**Consultation Response from KC,  
Lead Local Flood Authority**

**2025/90033 adj, 916, Halifax Road, Hartshead Moor, Cleckheaton, BD19 6LR**

**Erection of 12 dwellings with access from Halifax Road and associated works**

**Date Responded: 02/12/2025.**

Flow Control Details

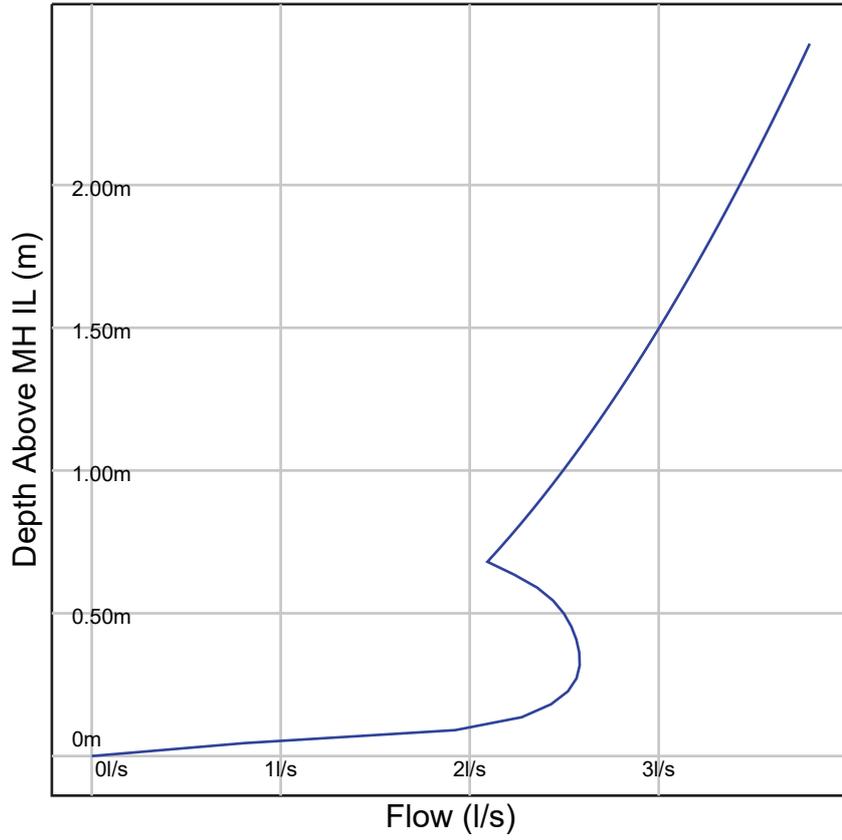
The Drainage Layout Plan refers to a 72mm diameter hydrobrake which is not acceptable (as noted in the LLFA's previous response). Please revise the drawing and re-submit to the Planning Officer.
